Our ref: DOC21/867736  
Your ref: SSD-14394209

**Subject: Bungendore High School SSD 14394209**

We have reviewed the Biodiversity Development Assessment Report (BDAR) by Kleinfelder Australia Pty Ltd dated 17 August 2021 submitted with the application for the above proposal and support the measures to mitigate impacts on biodiversity values during construction. These should be included as conditions of approval. In addition, Biodiversity and Conservation Division (BCD) also recommend the following measures to mitigate the ongoing indirect impacts of the development on the riparian values of Turallo Creek:

The Agricultural Plot is located north of the main high school campus, separated by Turallo Terrace. A new pedestrian crossing and a footpath between the main school campus and the Agricultural Plot connect the two areas.

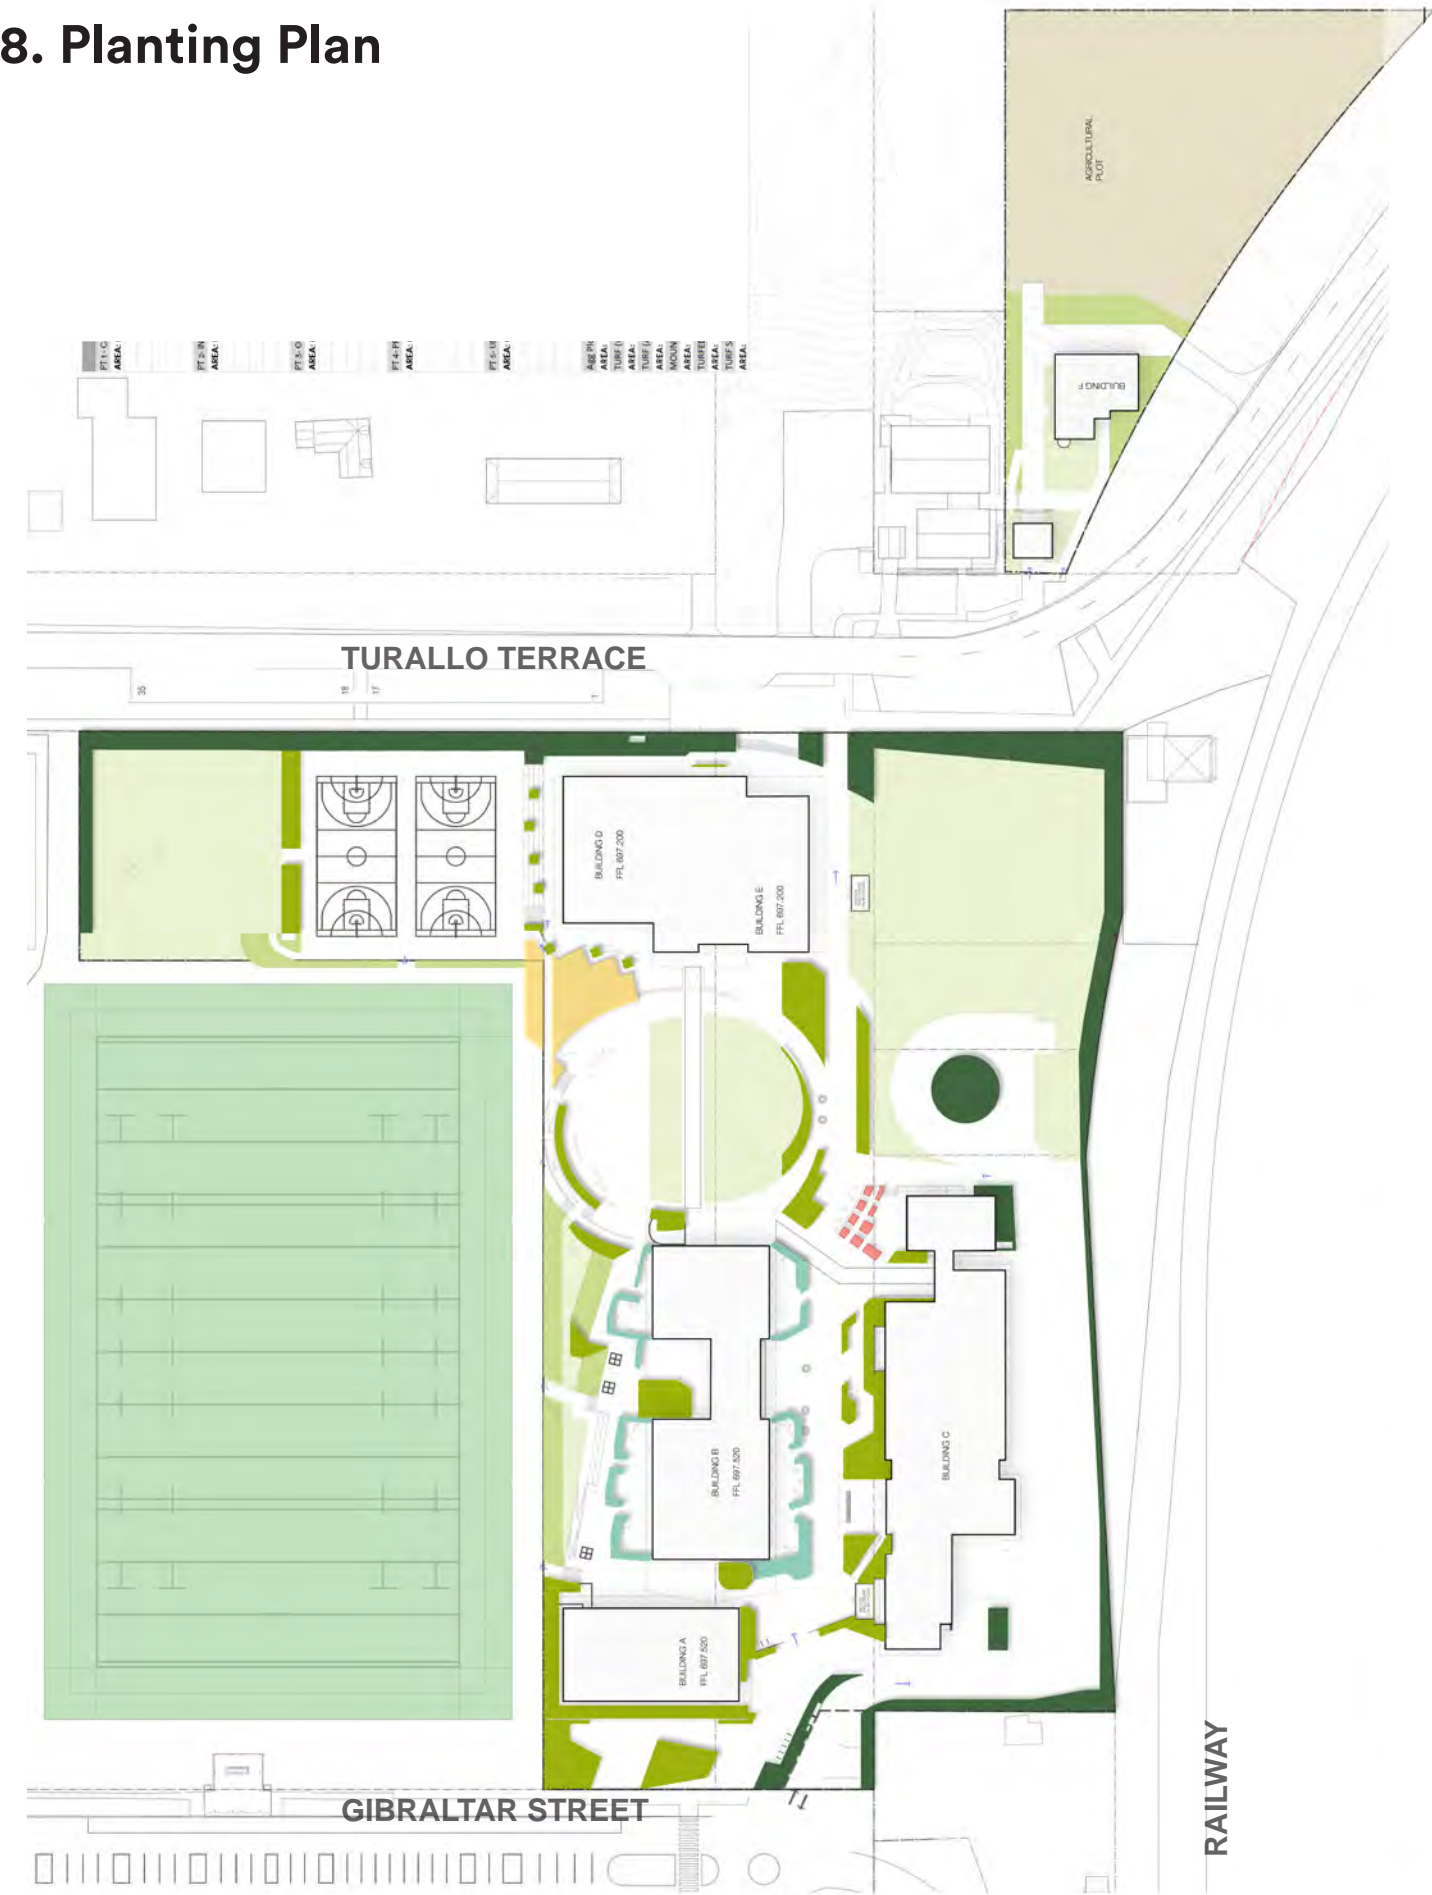
The BDAR however provides limited consideration of the ongoing indirect impacts that may be associated with the school's proposed agricultural plot on Turallo Creek post construction and during operation. Consequently, no recommendations for long term protection of the creek's riparian values are provided. Turallo Creek was not surveyed or included in the study area, however it is situated 60m from the plot boundary and is fed by a drainage line that crosses the agricultural plot.

Although there will be a 60m buffer, the plot is considered likely to comprise intensive agriculture and will have the potential to generate offsite impacts such as waste, nutrient and effluent discharge via the drainage line directly into Turallo Creek that may lead to degradation of riparian values. These impacts are not considered or addressed by the BDAR or EIS.

The EIS provides little detail of what the agricultural plot will comprise, other than that the plot will be surrounded by 2.1m high chain wire fencing.

BCD acknowledge that the development provides a 60m buffer to the watercourse, however safeguards to mitigate these ongoing impacts and ensure that the buffer is maintained for the life of the development should be provided.

BCD recommend that all activities are restricted to the approved development footprint and that the 60m (60m buffer) separation from the riparian habitats is maintained for the life of the development- i.e. there shall be no encroachment of agriculture, gardens or livestock into the 60m buffer.

We also recommend a pollution bund or some form of pollution control to be constructed and maintained around the plot to restrict the discharge and overland flow of effluent and nutrient discharge from the site.

As part of the landscaping and groundskeeping, we also recommend that the area between the plot and Turallo Creek is maintained in a weed free state for the life of the development.
